Your ref: SSD 7198
Our Ref: 0820732

**SSD 7198 – Moonee Beach Residential Subdivision
Interim Response to RFI issued 15 July 2019**

Attachment A
Revised Subdivision Plans – Civiltech

CAD file: 1277-DR4J.dwg

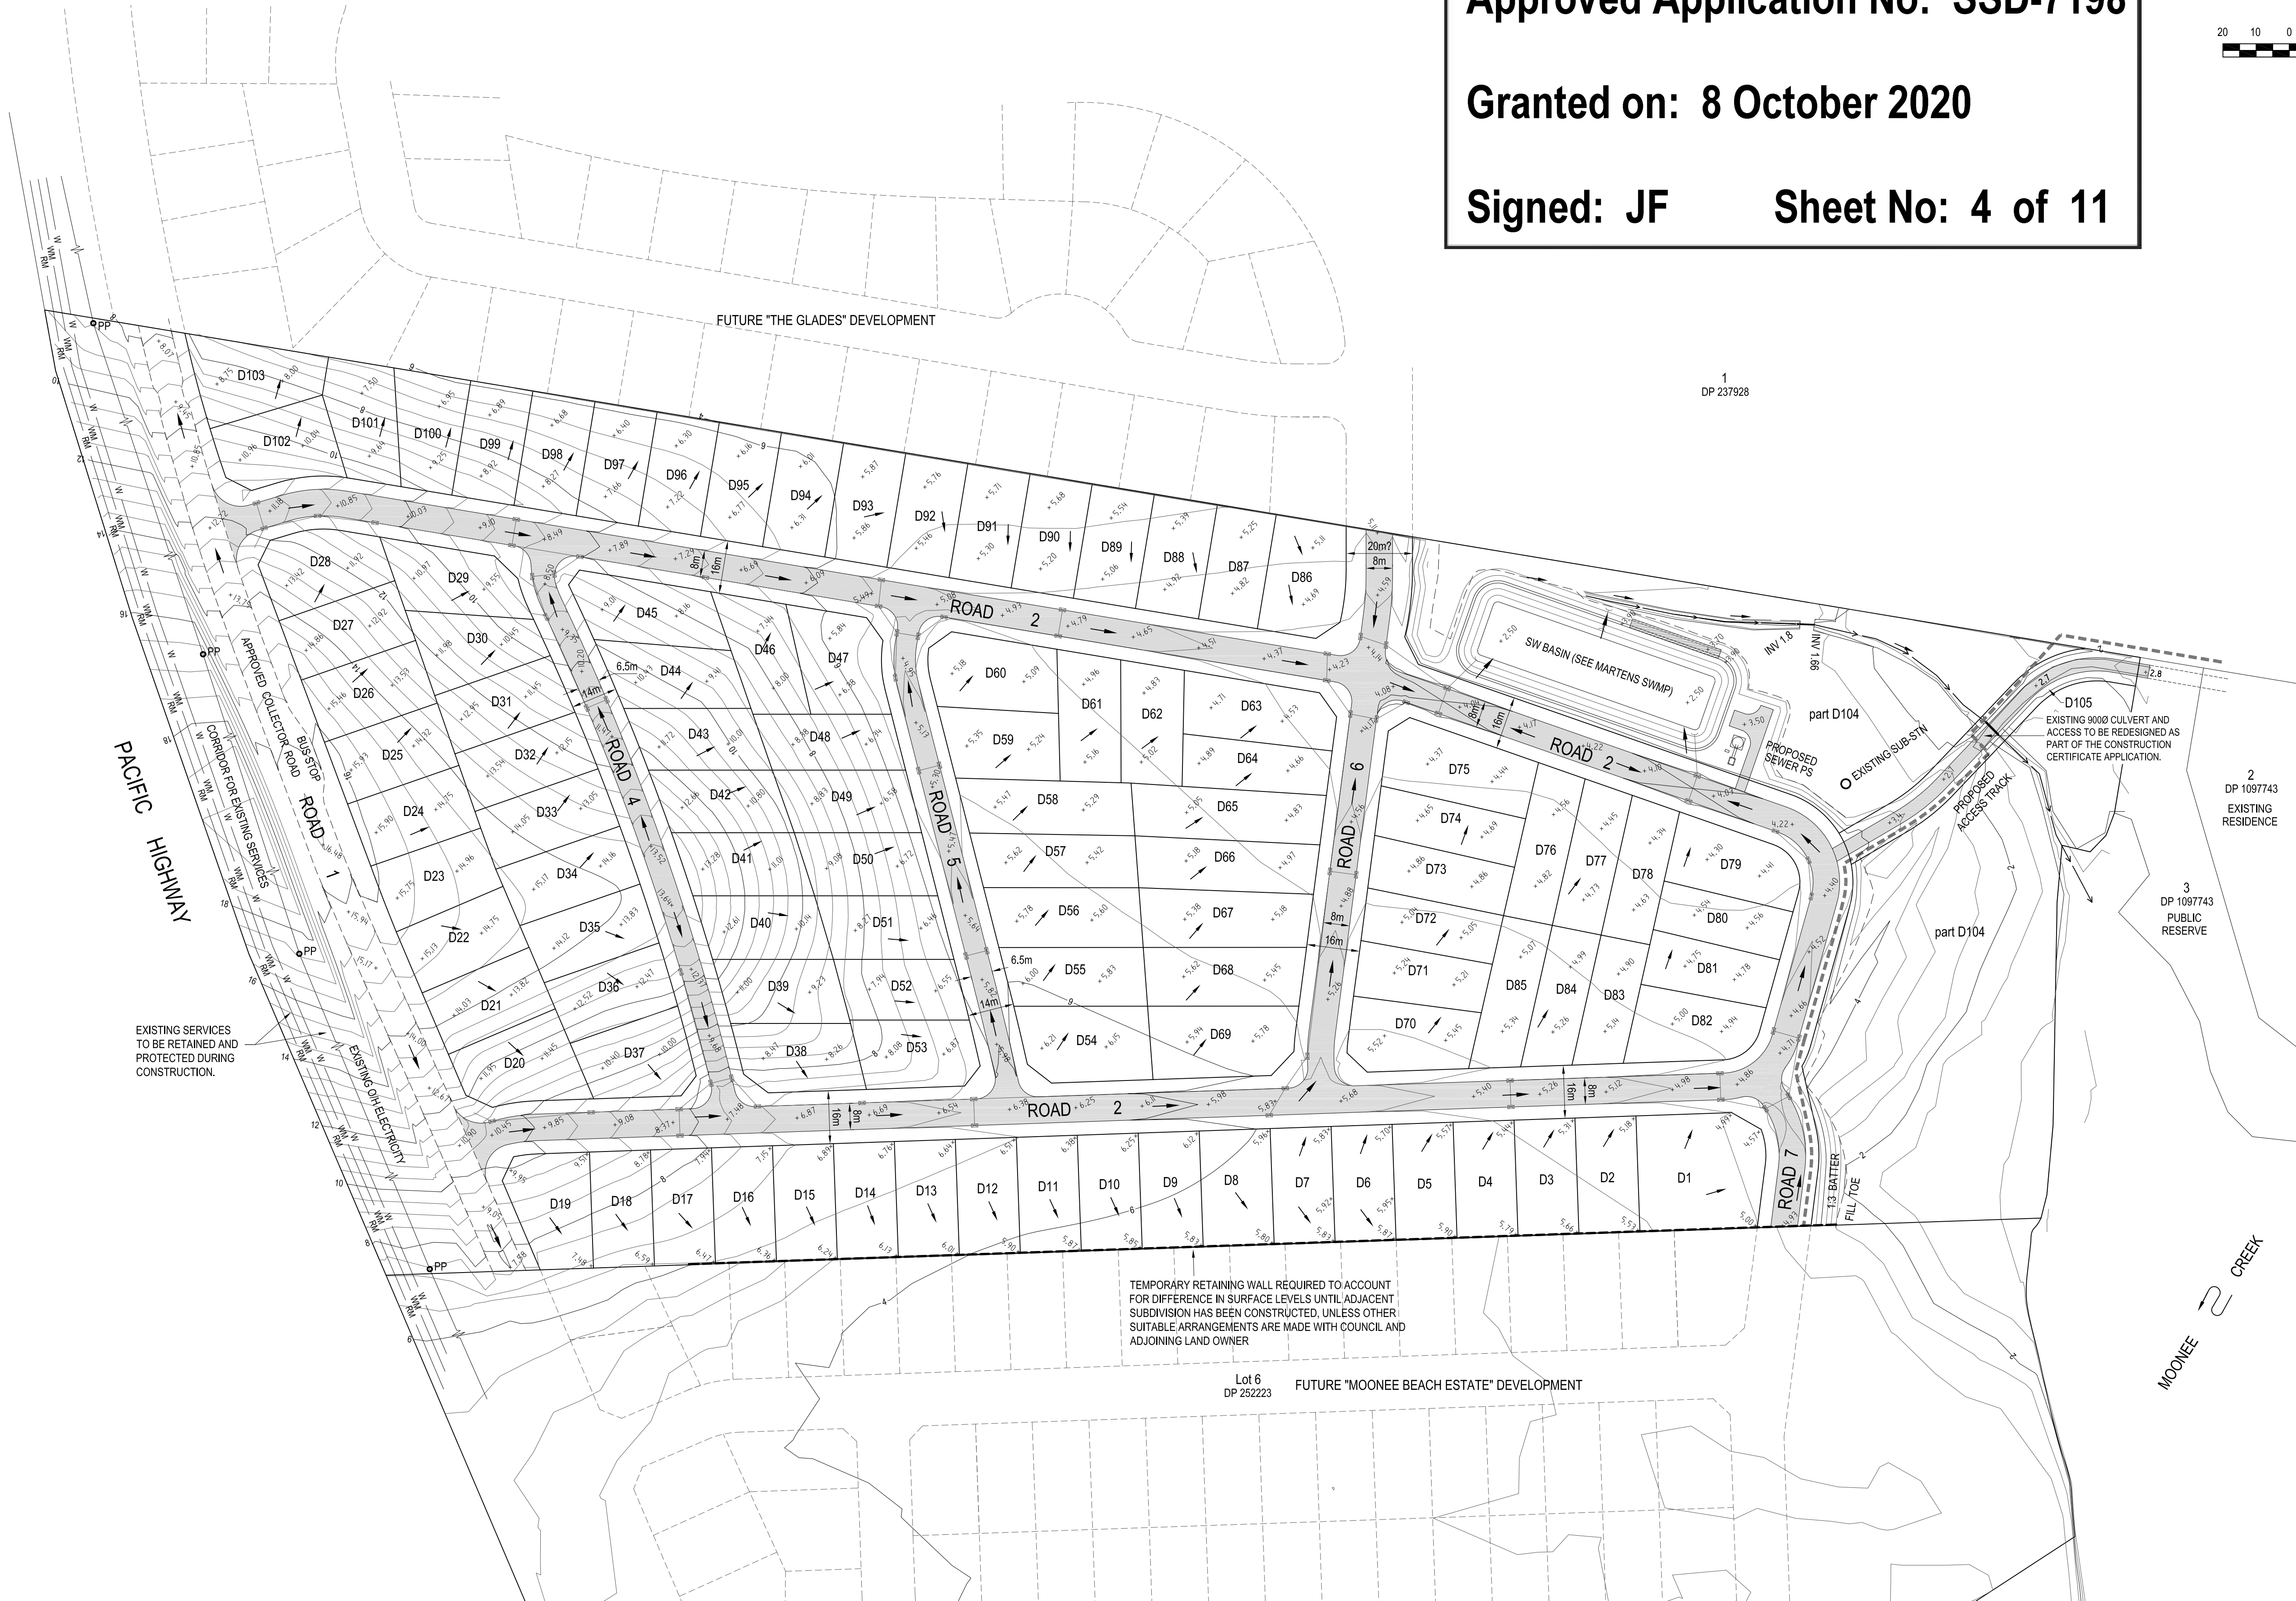
The difference in levels between the southern boundary and the levels on the adjoining site do not appear to have been addressed. The Department requests the plans be amended, in consultation with the adjoining Applicant, to ensure fill levels are consistent between the two sites to address privacy concerns, management of stormwater impacts, minimise retaining walls on-site and allow for integrated sewer and road infrastructure.

Response: The fill levels along the southern boundary have been amended to integrate with the adjoining development.

PROPOSED SUBDIVISION
STORMWATER LAYOUT
AND CATCHMENT PLAN
0.5m FINISHED CONTOURS

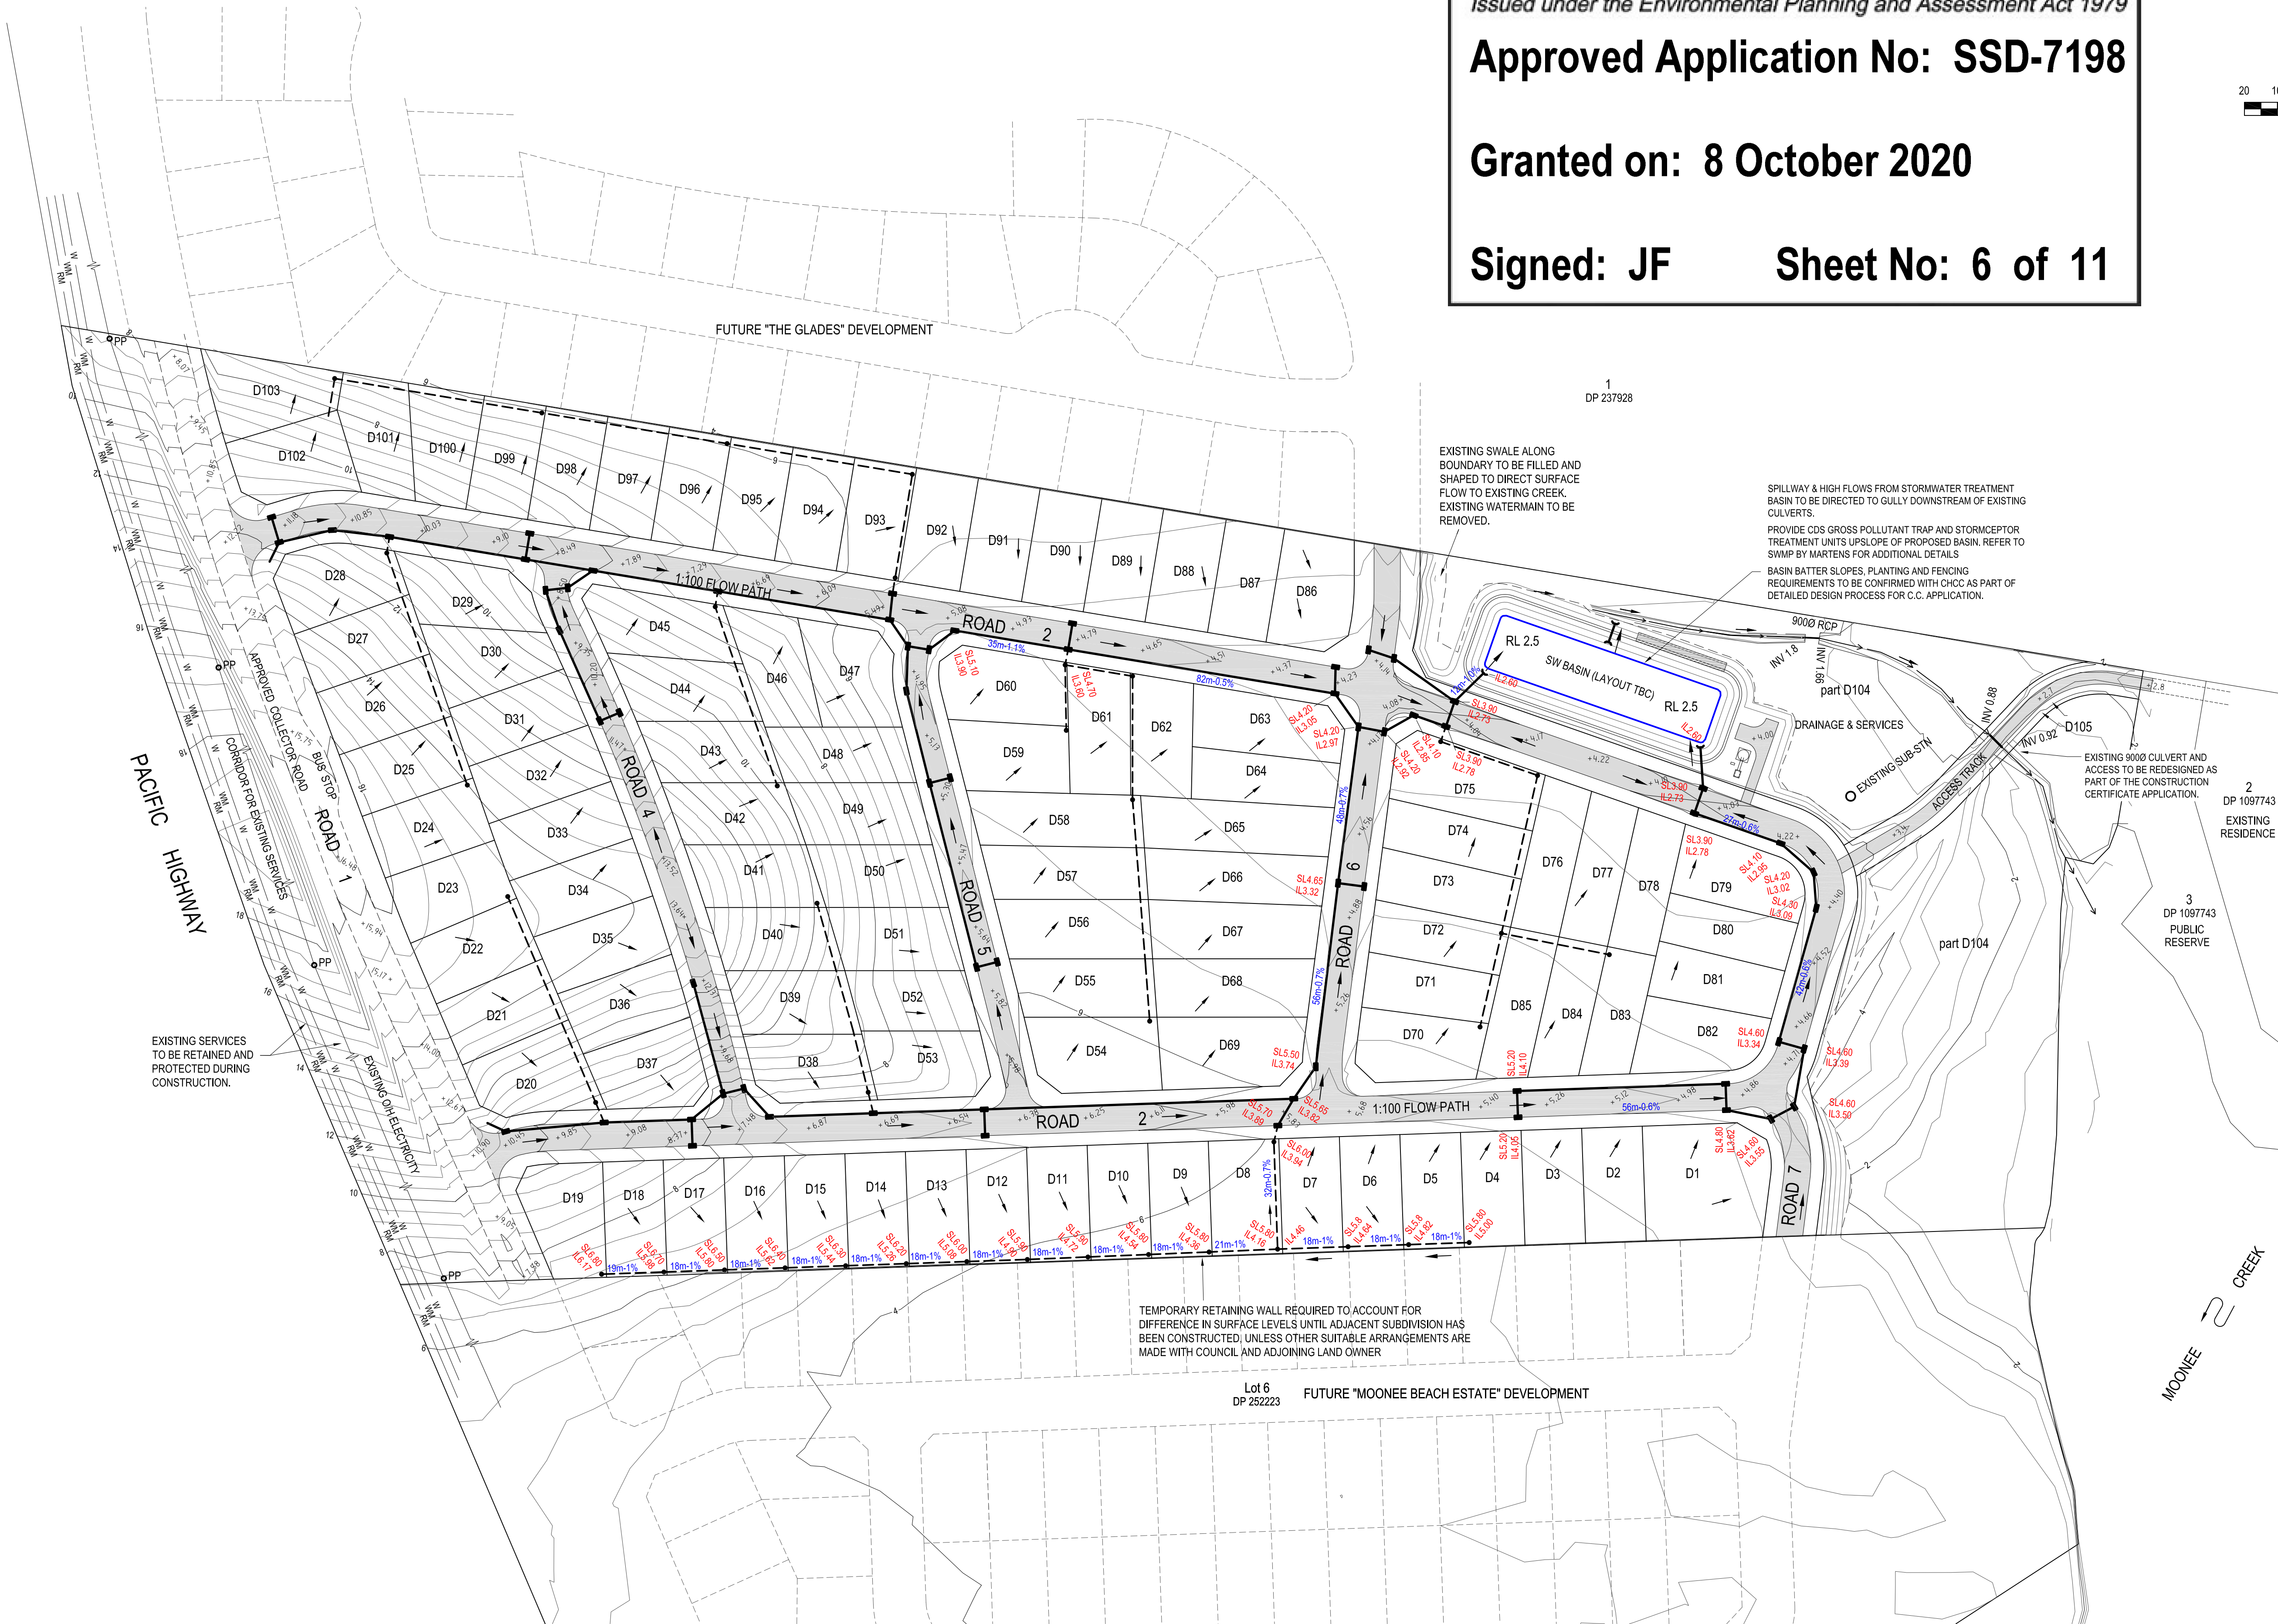
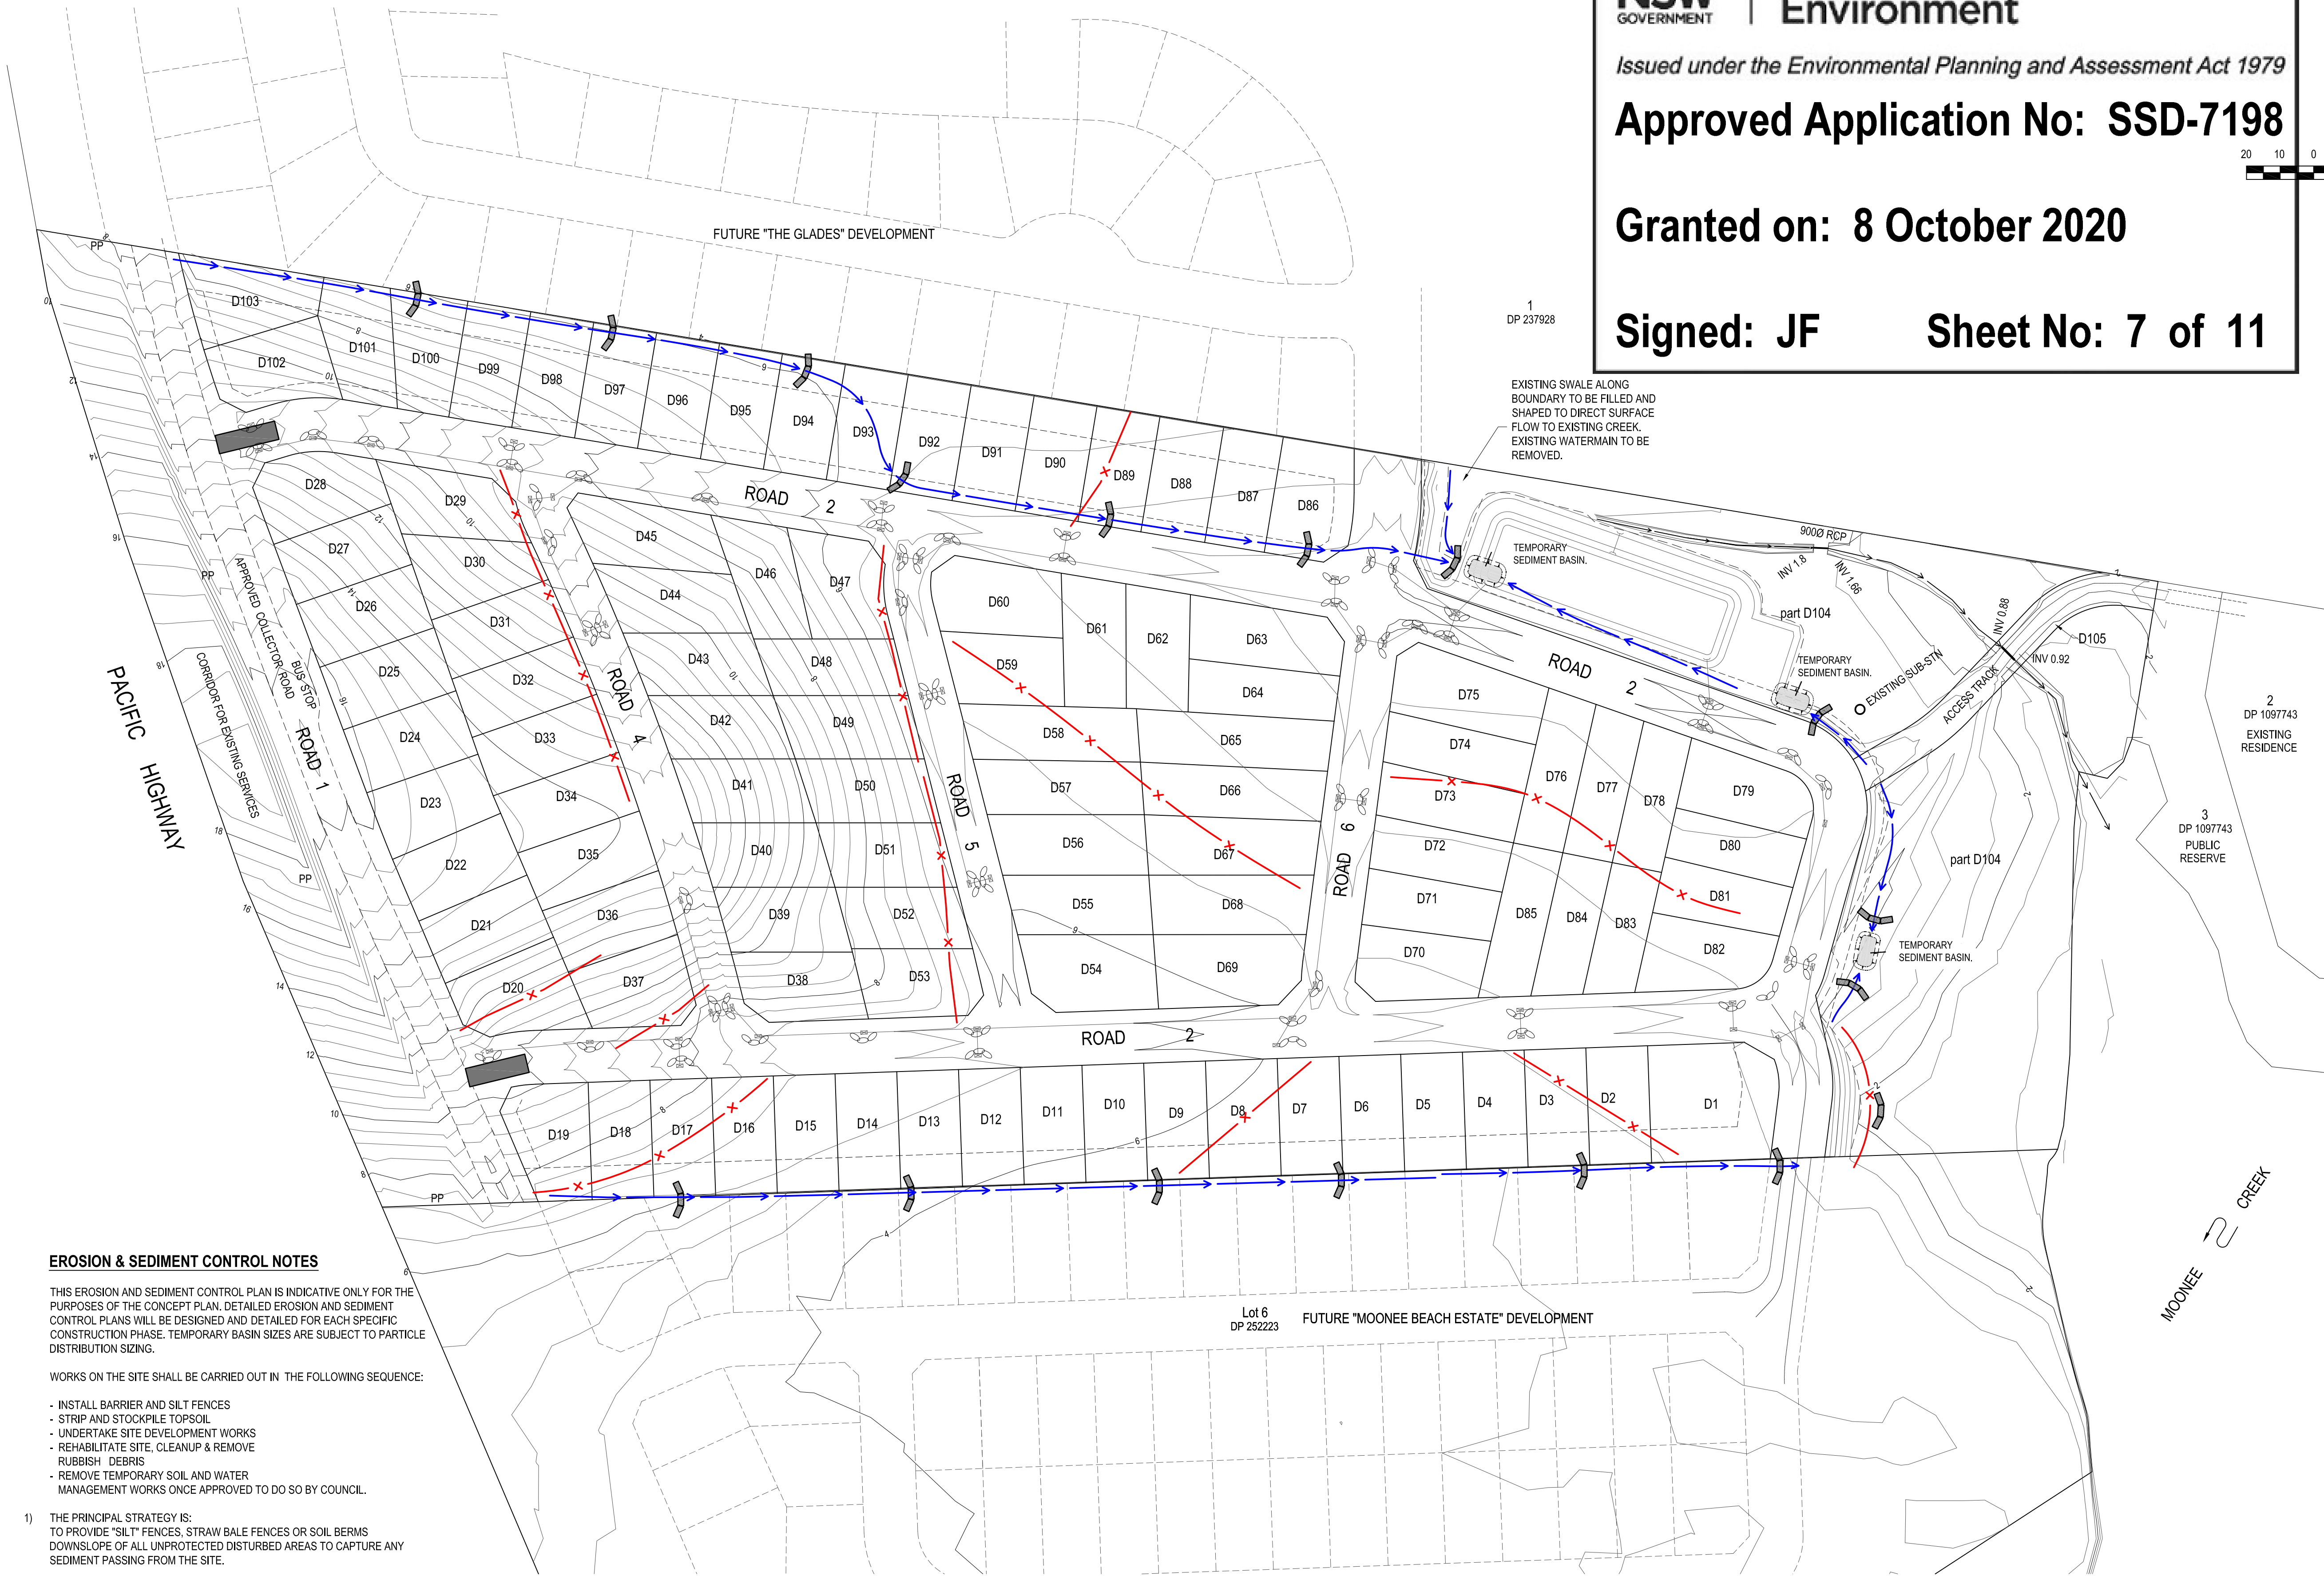
The stormwater plans show the southern boundary swale discharging through Council's reserve into Moonee Creek. As Council has advised it will not accept the public reserve as a discharge location, the plans will need to be amended to remove the open swale and demonstrate that discharge will be conveyed into a retention basin.

Response: The stormwater swale has been removed and inter-allotment drainage added to drain the southern lots to the proposed retention basin. The new link road (Road 7) has a high point at the southern boundary to ensure that the stormwater flows are directed to each internal basin. No concentrated stormwater flows discharge through the reserve to Moonee Creek. Levels on the critical lines are shown on the stormwater plan.
